From: Michael Eastham <Michael.Eastham@arun.gov.uk>
Sent: 07 January 2021 16:12
To: Planning.Responses <Planning.Responses@arun.gov.uk>
Subject: FW: Y/131/20/DOC - Land at Ford Lane, Yapton

Please upload the email below which is a further consultation response from the WSCC Rights of Way Team to discharge of condition application Y/131/20/DOC.

Please find attached a copy of the revised cycle route plan for discharge of condition application **Y/131/20/DOC**.

Movement Plan

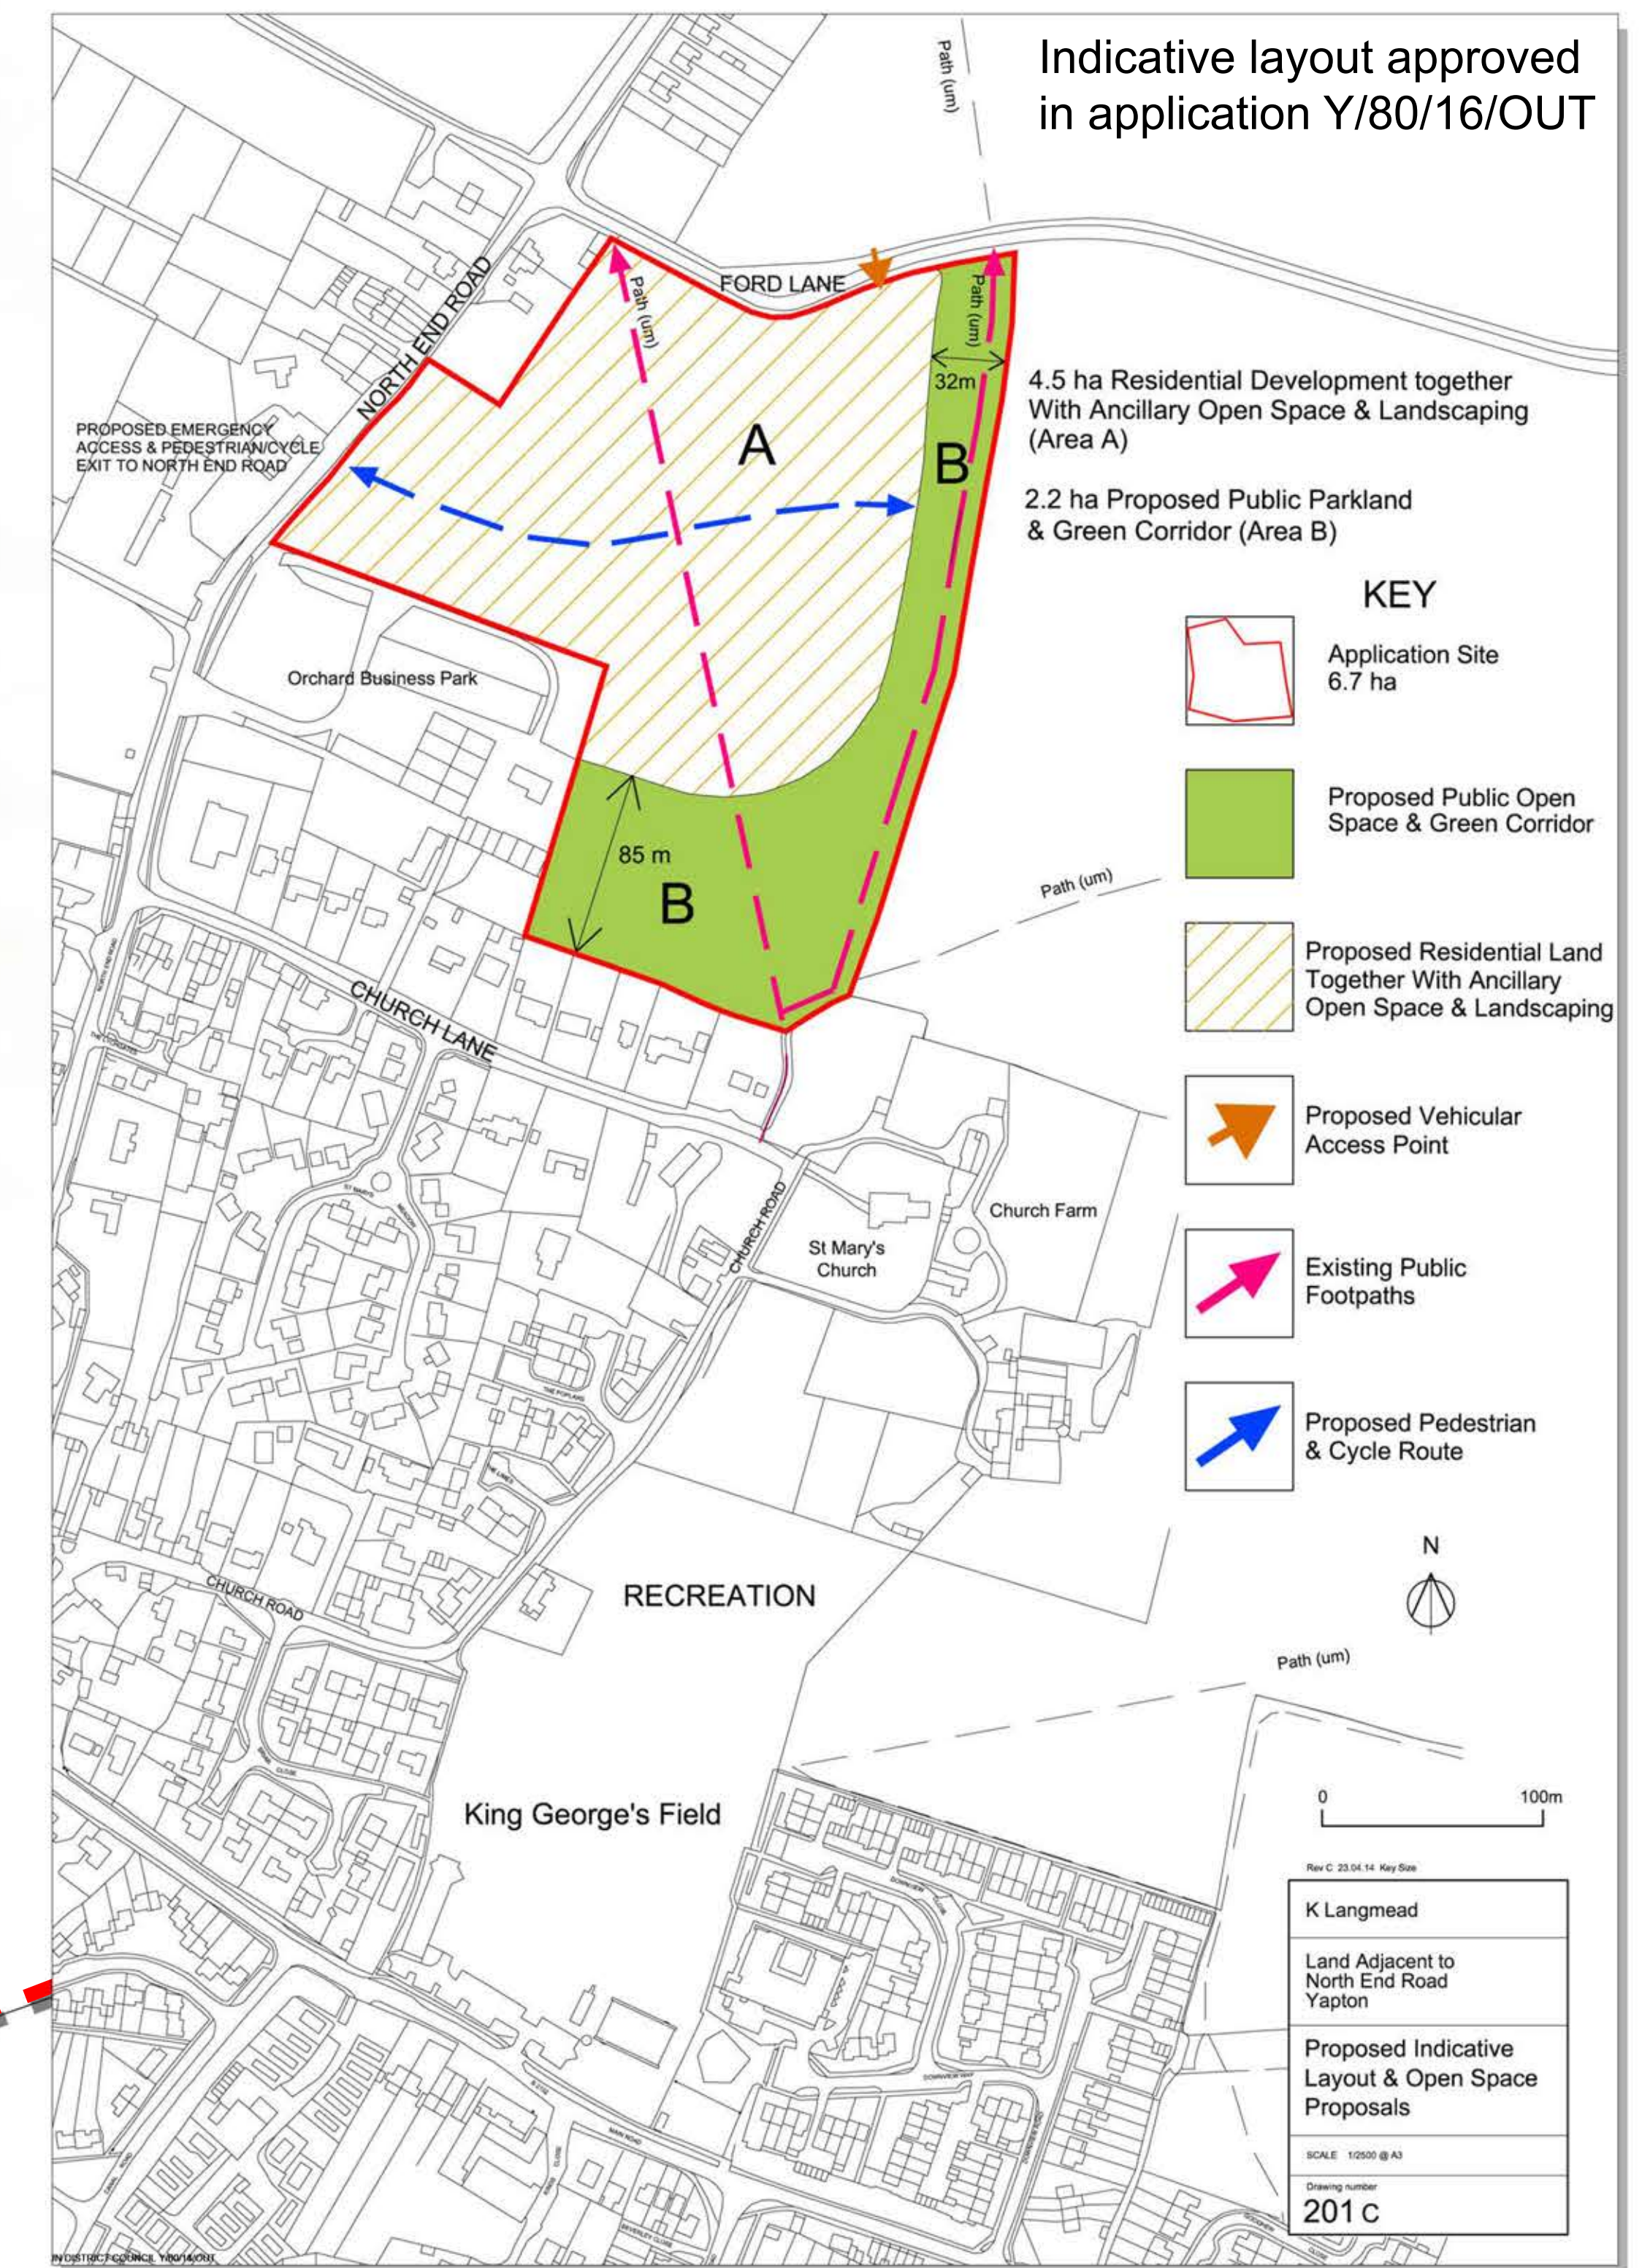
The line looks acceptable to me, it will need a 3m width and agreed surface.
